Consultation Response from Biodiversity Officer
KC Ecology
2019/90634 adj, Netherfield House, 12, Riley Lane, Kirkburton, Huddersfield, HD8 0RY
Erection of detached dwelling with associated landscaping, incorporating existing garage and private driveway
Date Responded:
07/06/2019
Responding Officer:
Tom Stephenson
Responding Ref:

Drawing:
Tree Constraints Plan

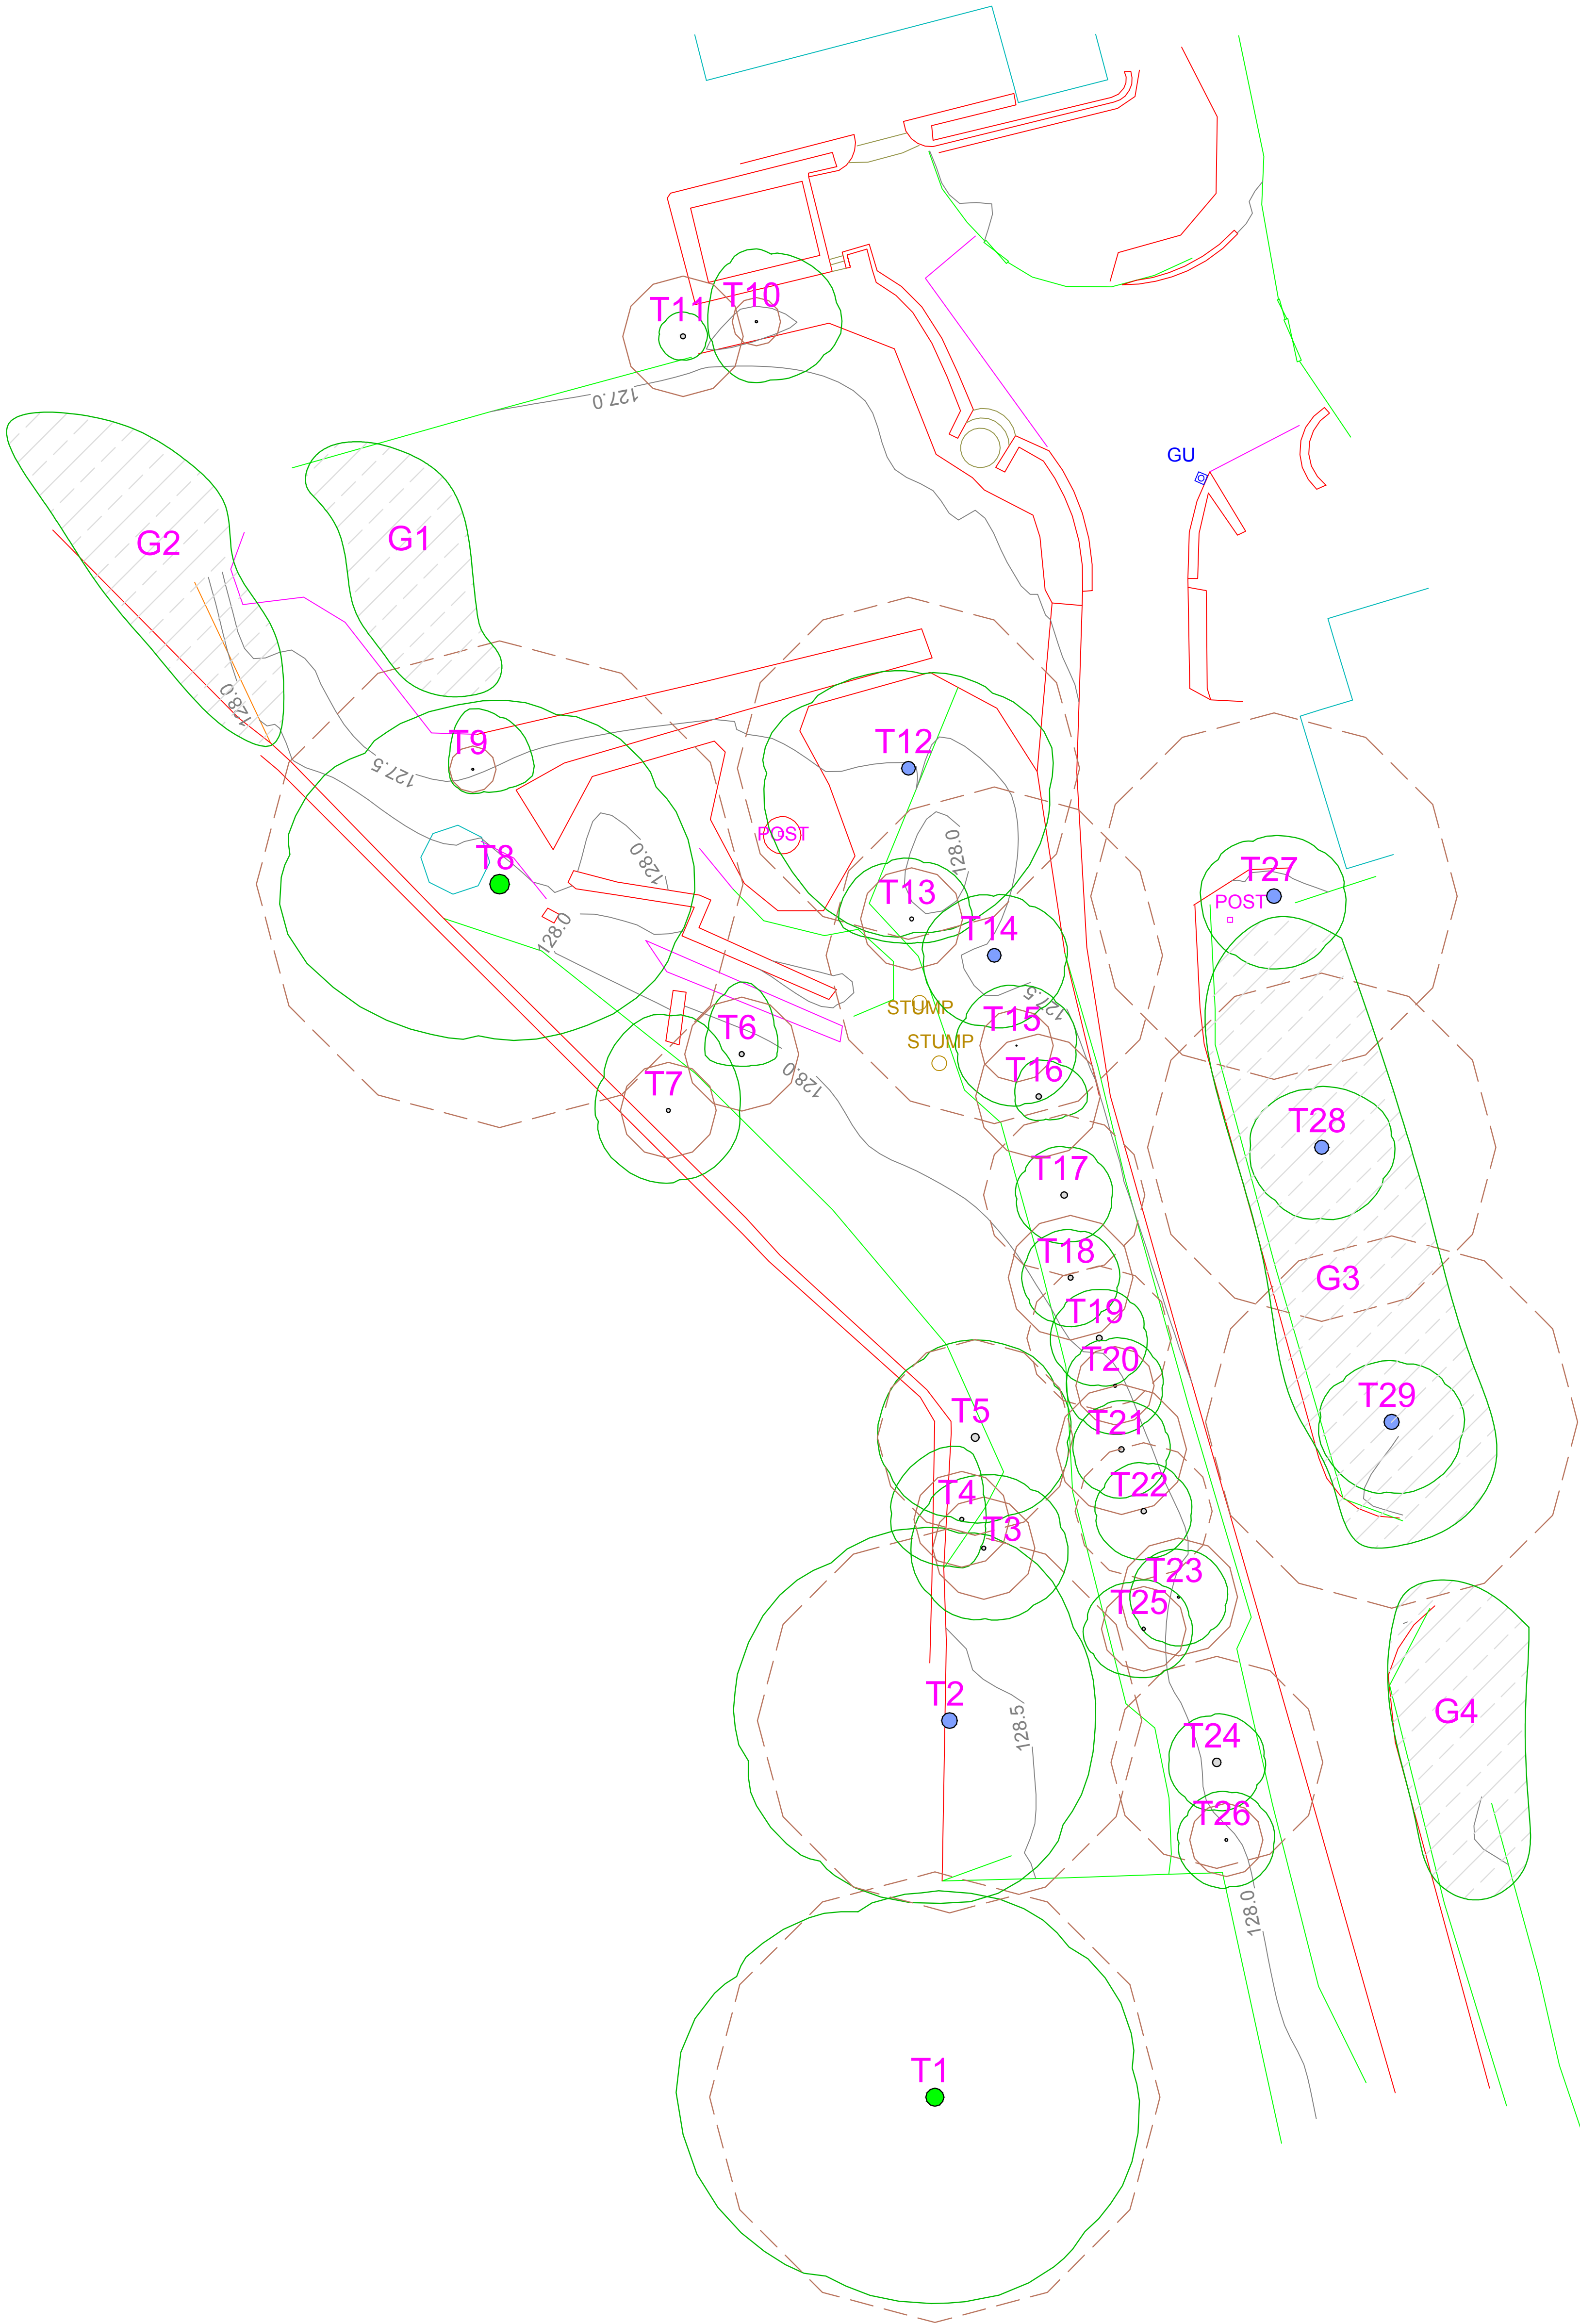
The report recommend further bat activity survey to determine the presence or likely absence of roosting bats within trees that are to be impacted by the proposals. This survey information is required in order to assess the potential of the scheme to result in significant ecological harm. There is no indication within the report of which trees within the site have bat roost potential.

client	Mr. & Mrs. R Napier
project	12 Riley Lane, Kirkburton
drawing title	Indicative Drainage Plan
drawing number	017009_103
revision	-
drawing status	Planning
scale	NTS @A3
date	10.02.2019
drawn by	-
checked by	-

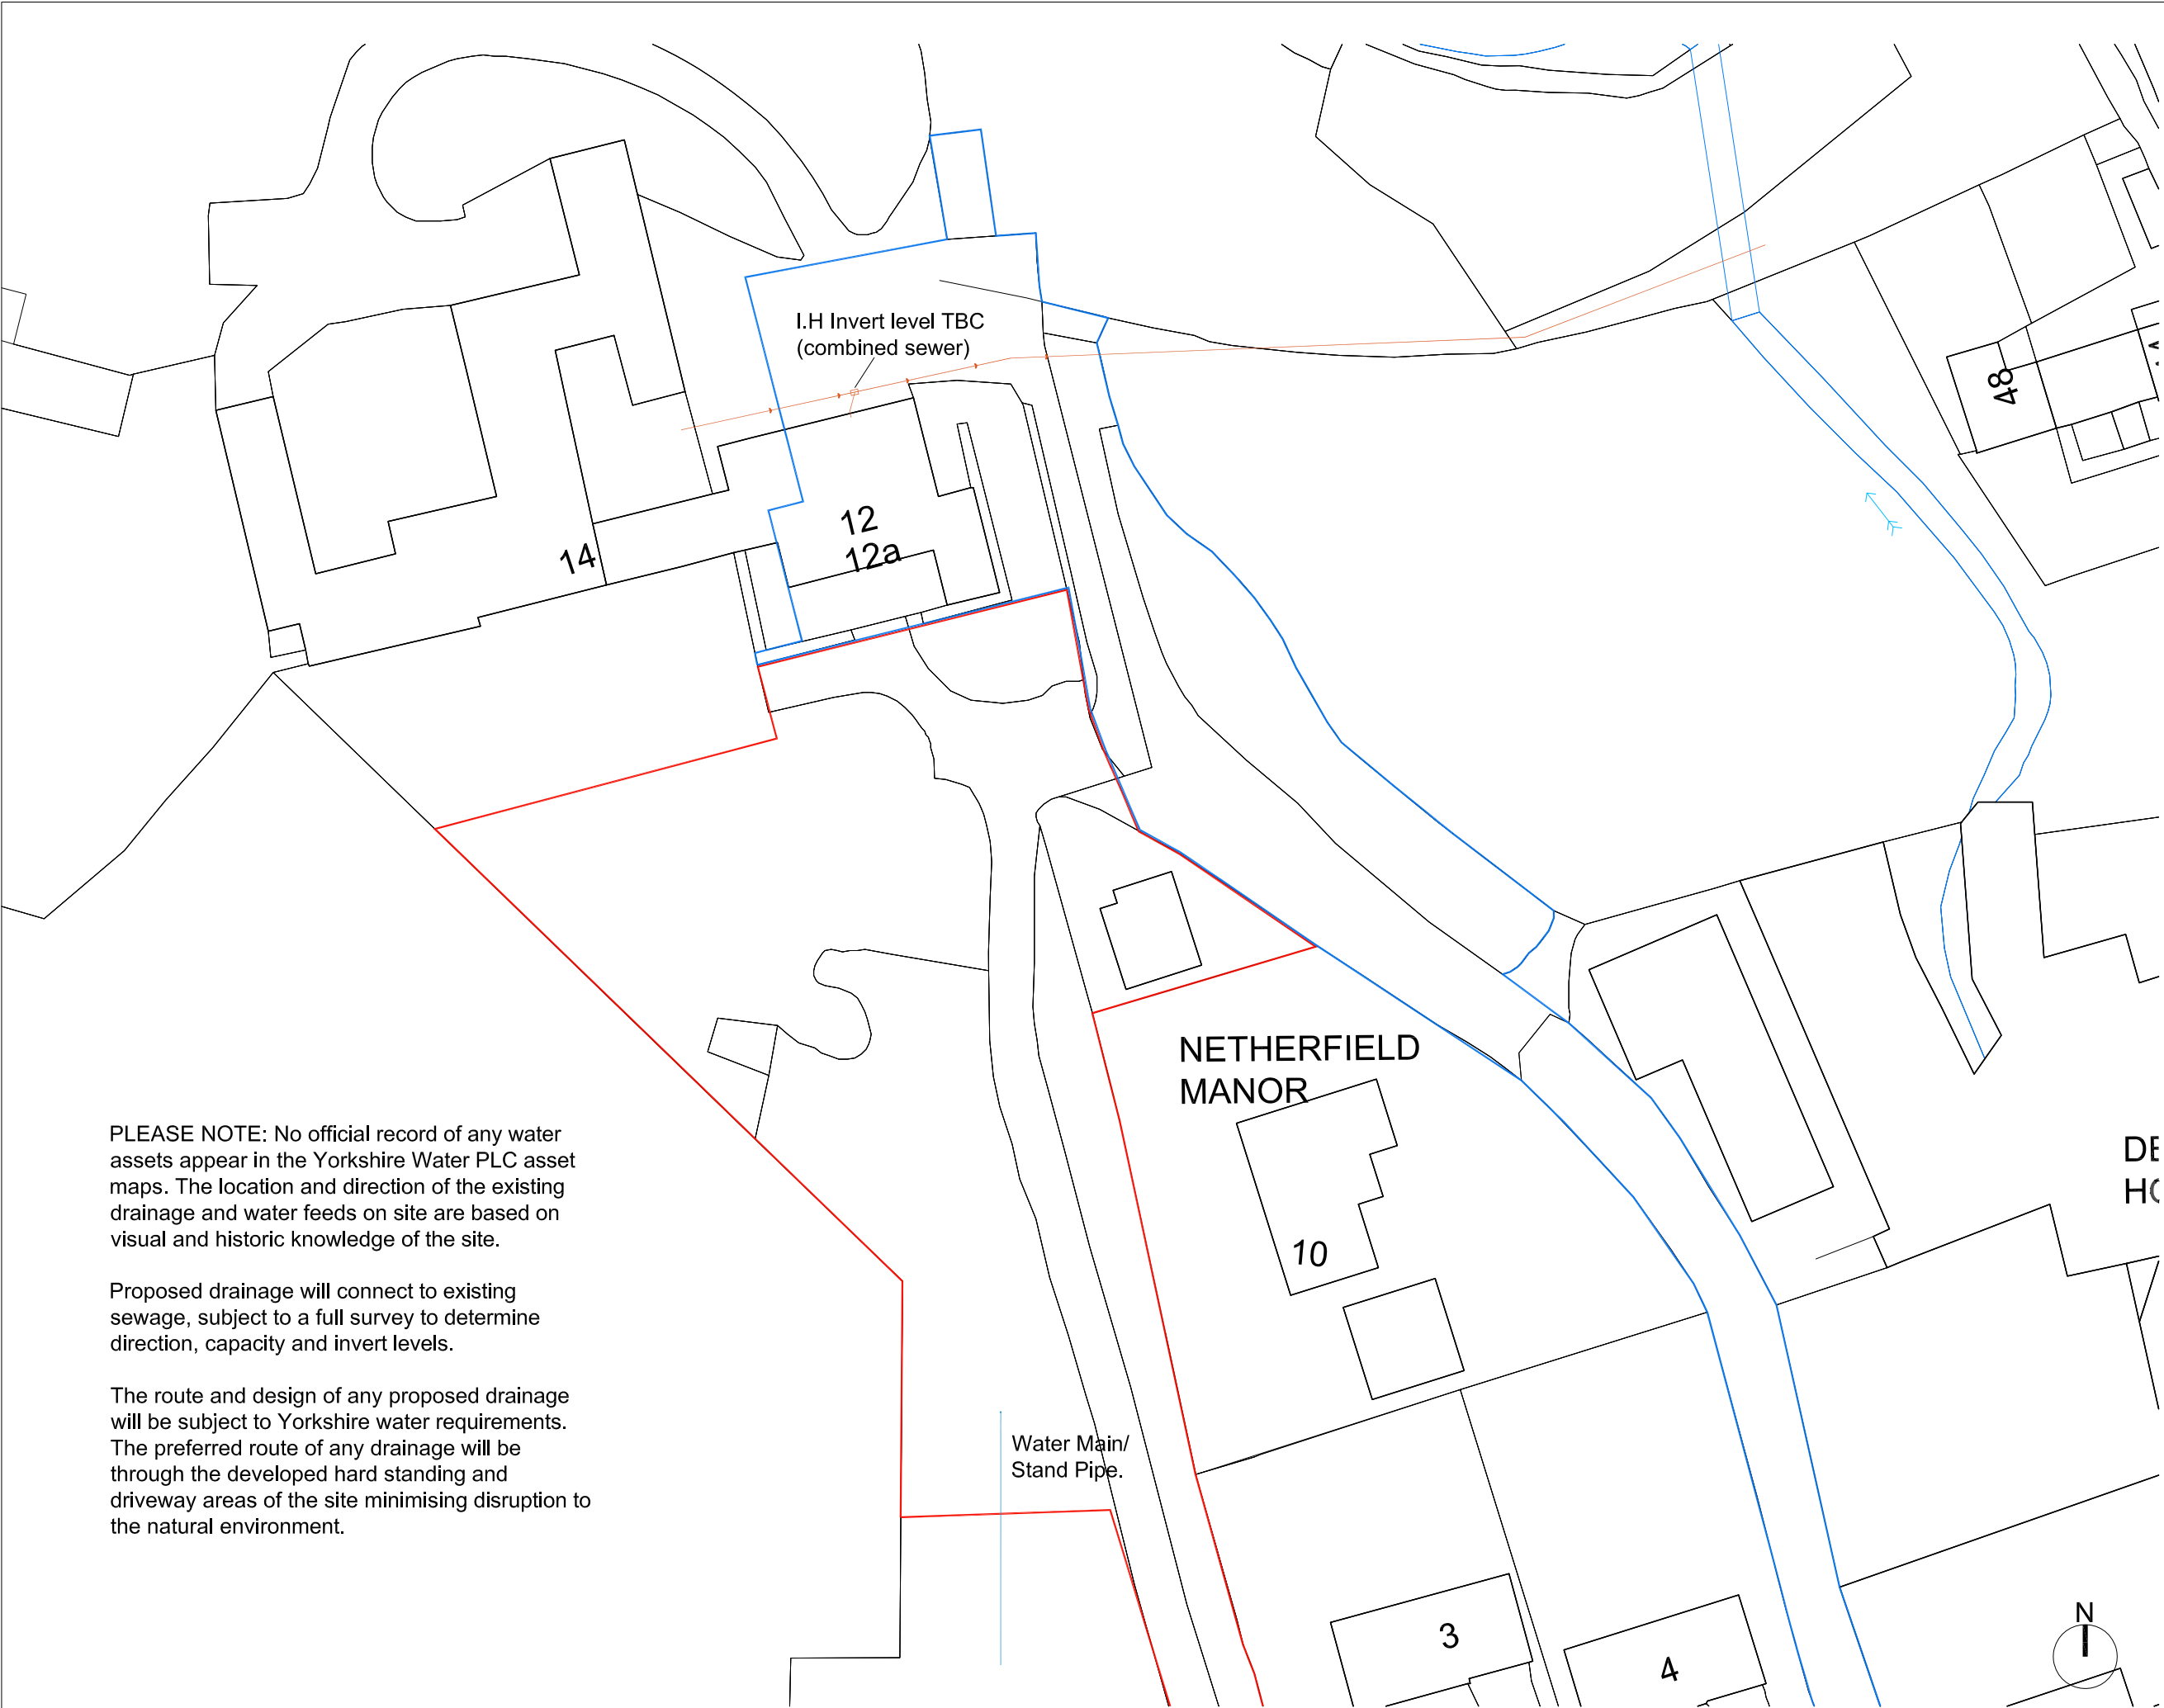
I am also unclear on where the site includes a pond. The existing site plan submitted by the applicant shows a pond within the site, however the ecological report states that no ponds are present within the 250 m of the site. If a pond is present this will need to be assessed for its potential to support great crested newts.
